Consultation Response from KC Highways Development Management		
2025/91127 Oxford Grange, 30 Oxford Road, Dewsbury, WF13 4LL		
Change of use of residential care home to 21 apartments, erection of coach house to host 2 apartments with associated external works (within a conservation area)		
Date Responded: 02/04/26	Responding Officer: M Zenner	Responding Ref: 14-10SW/22

RECOMMENDATION: Amendments and further information required.

SCALE @ A3: 1:250	CHECKED: AT	APPROVED: AT
CAD FILE: 26017-SPA_VIS.dwg	DESIGN-DRAWN: TS	DATE: 26/05/2026
PROJECT No: 26017	DRAWING No: 26017/VIS/001	REV: A

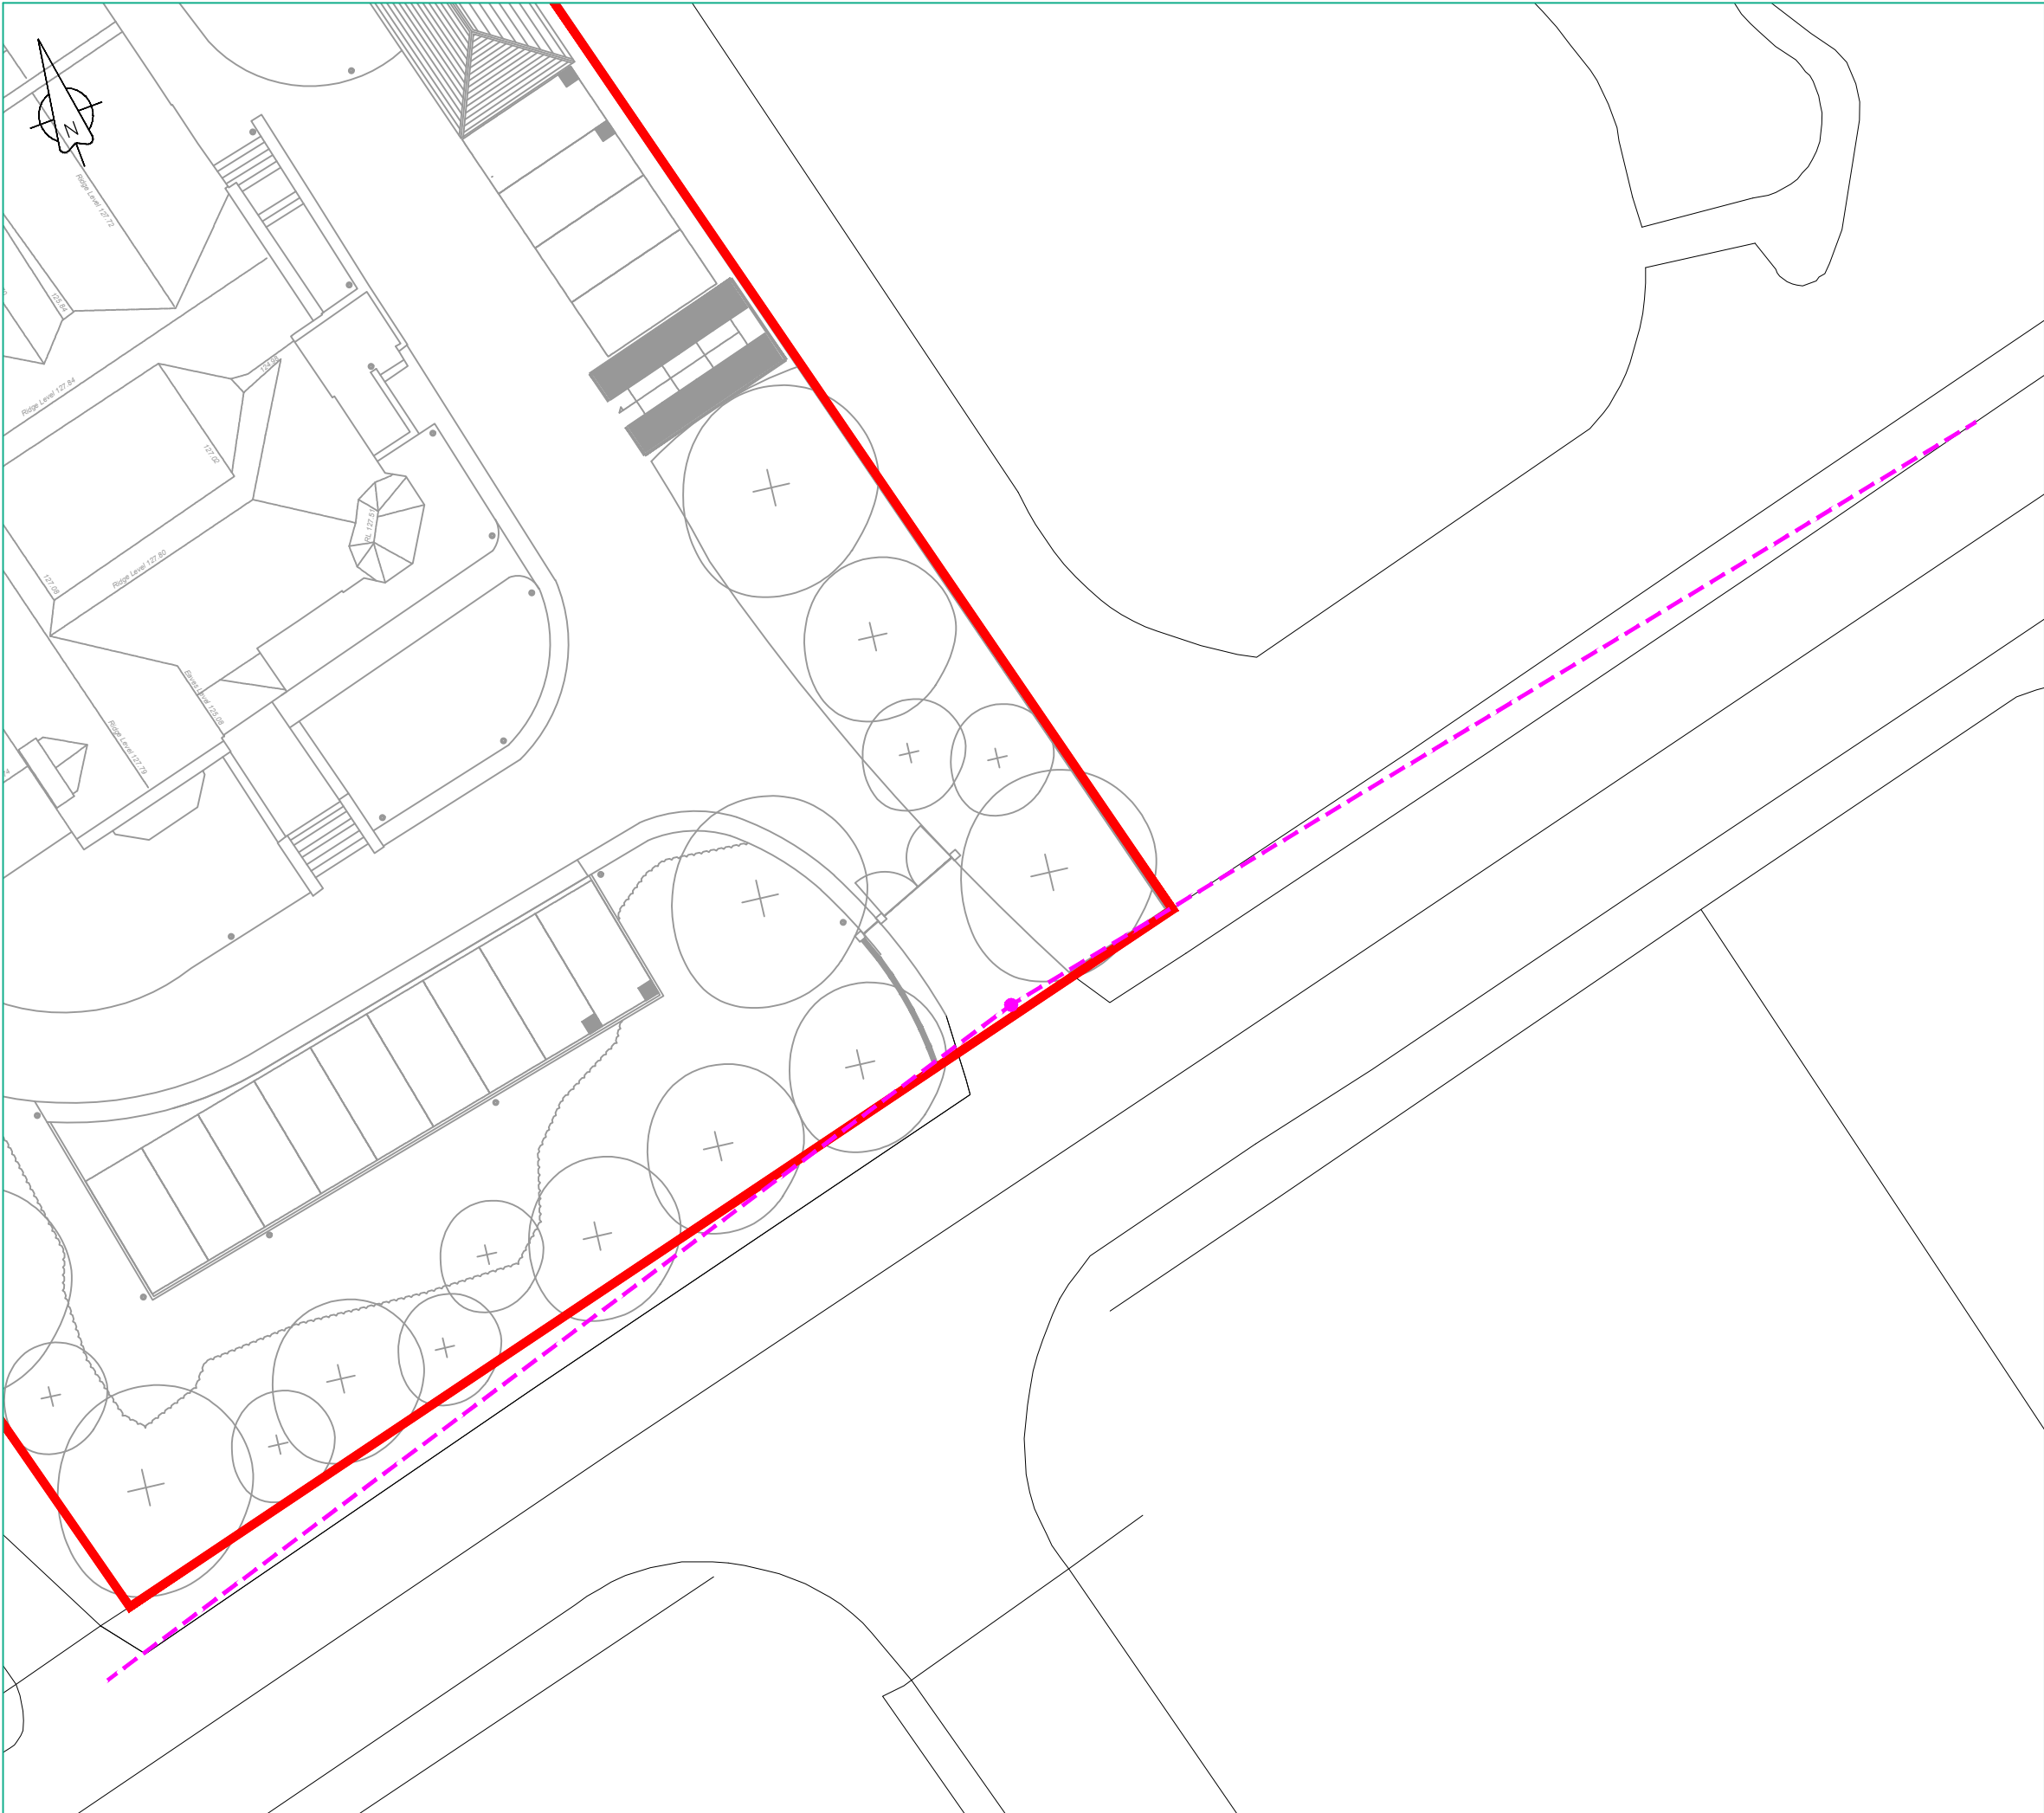
The proposals appear to use the existing site access for the proposed vehicular access; however, no details have been provided in relation to the width or arrangement of the proposed site access. At present there is a stone wall across the site frontage with substantial piers either side of the site access. This is not shown on the submitted block plan and no details are provided in relation to existing or proposed visibility splays at the site access.

The proposed access width on the block plan is approximately 3m width which is not adequate for simultaneous access and egress and therefore could result in vehicles blocking the public highway, which is not acceptable on highway safety grounds. The site access should be a minimum of 4.5m wide for the first 5m of its length (5m if there are structures along its initial length) to allow vehicles to turn in and turn out.

Visibility splays should be demonstrated to comply with Manual For Streets requirements for a 30mph road of 2.4m x 43m in either direction.
